Ribble Valley Borough Council
Housing & Development Control

Application no: **3/2021/0803**

Address: **Fell View Barn Barret Hill Brow Bolton by Bowland BB7 4PQ**

Proposal: **Proposed change of use of agricultural building to education barn.**

PROPOSED SITE PLAN

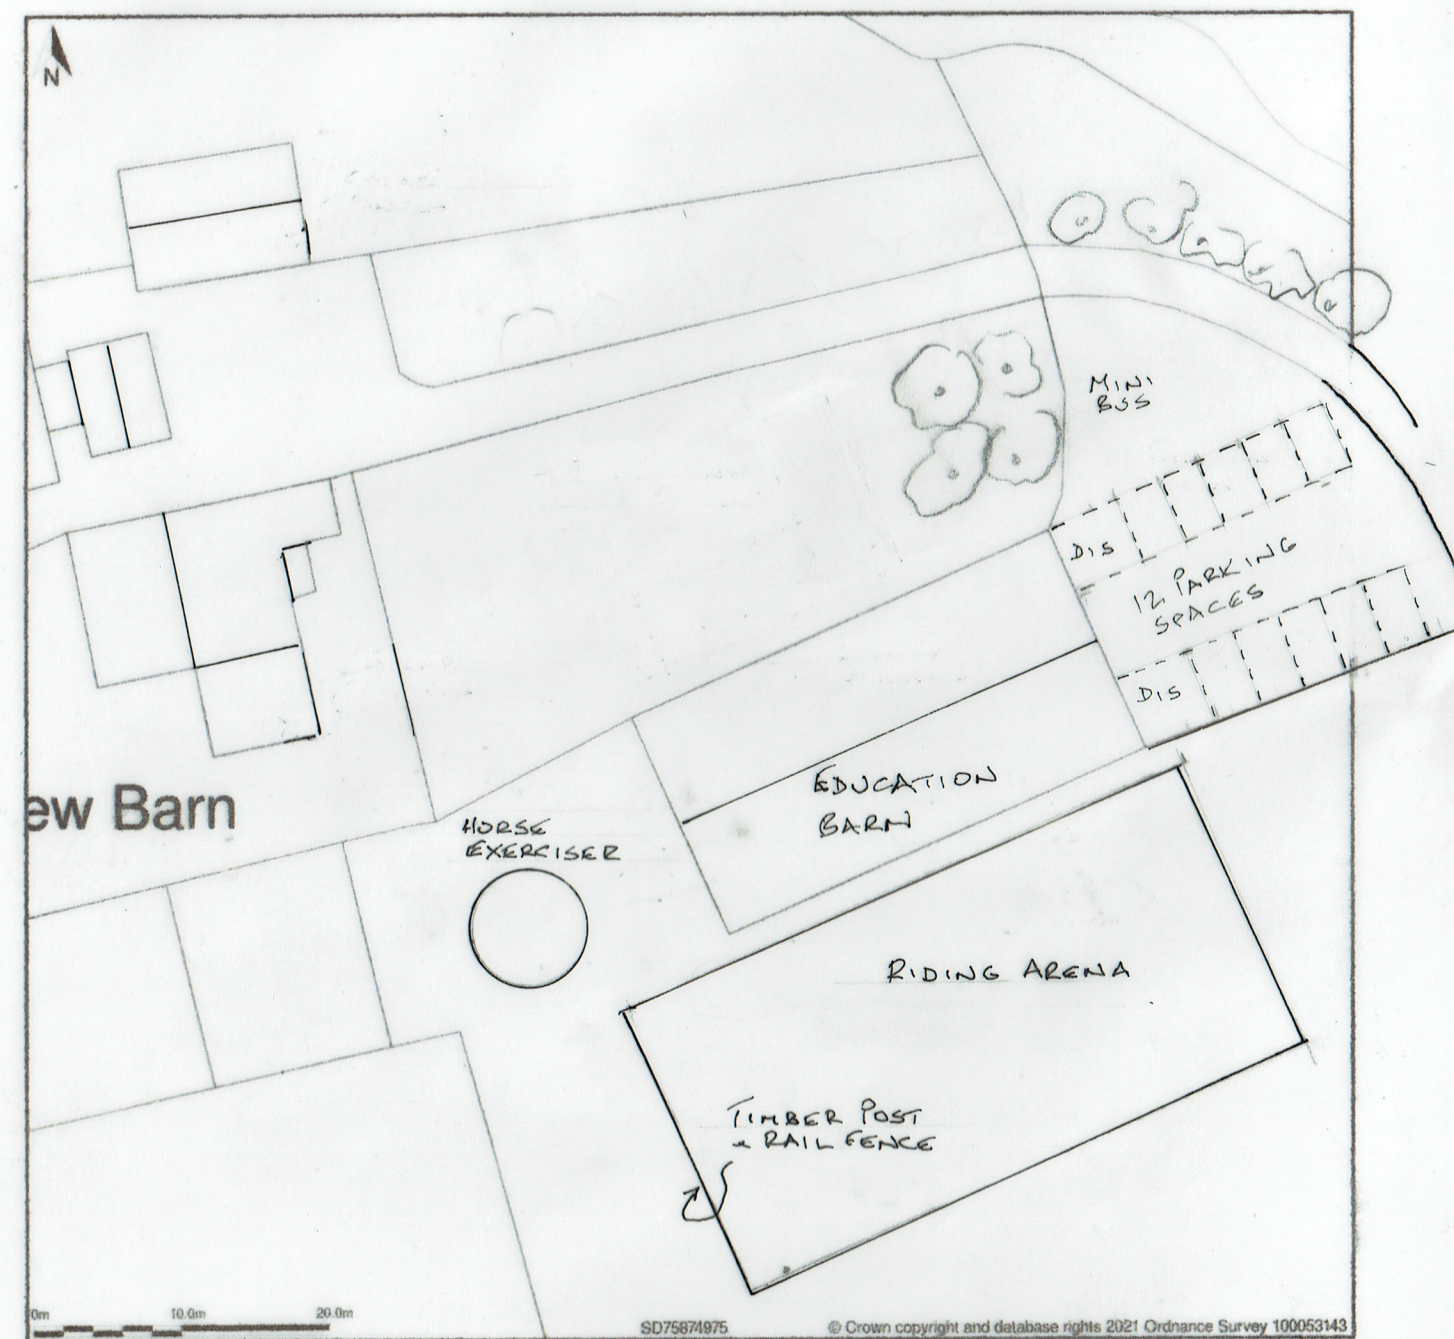
The LHA have reviewed Buy a Plan drawing titled "Parking Plan" and understands that the site will provide 12 car parking spaces including 2 disabled spaces. While the LHA would normally require an education barn with the internal floor area

measuring 450 square meters to provide 13 car parking spaces as defined in the Joint Lancashire Structure Plan, the LHA in this case will accept the shortfall.

2. The development hereby permitted shall not be occupied until such time as the parking and turning facilities have been implemented in accordance with Buy a Plan drawing titled "Parking Plan". Thereafter the onsite parking provision shall be so maintained in perpetuity.
